R/4/22/DOC

Elm Cottage 30 The Street Rustington BN16 3NX

Approval of details reserved by condition imposed under ref R/305/18/L relating to Condition No 3 - materials and finishes - joinery details (including details of the sealed glazed units).

Horizontal Section 1:5 @ A4

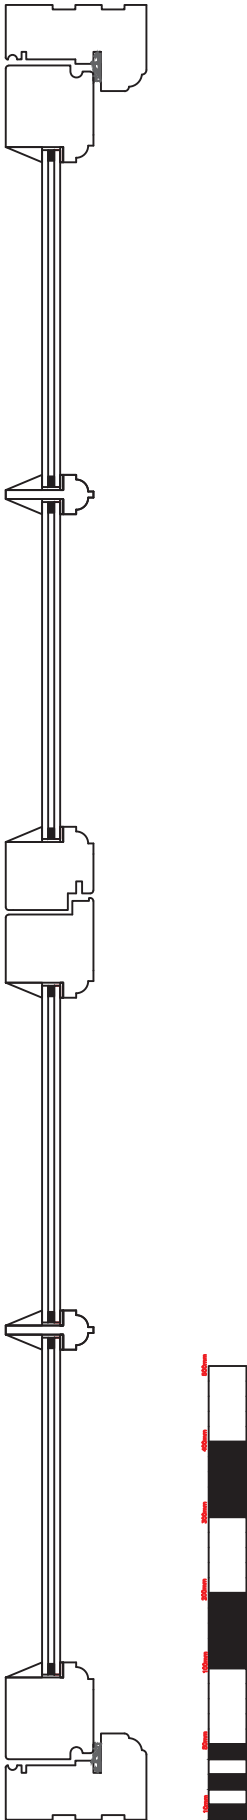
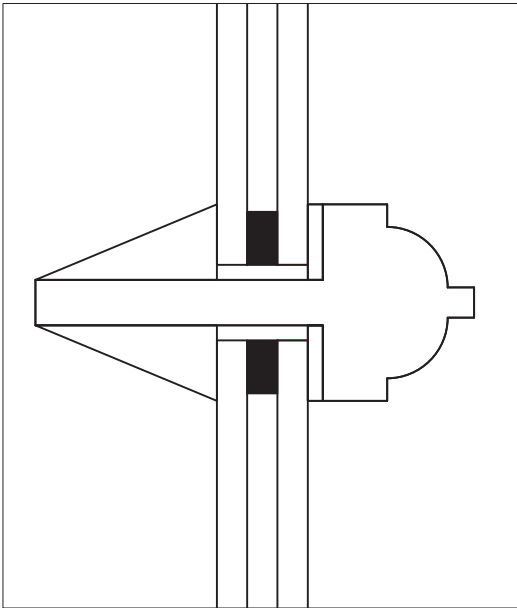
The use of the slimmer glazed units (12-14mm) is acceptable, as are the details of the details of the windows themselves.

The condition asks for materials and finishes of the windows, and it is to be assumed that the windows would be timber, painted white. If this is correct, the condition can be discharged.
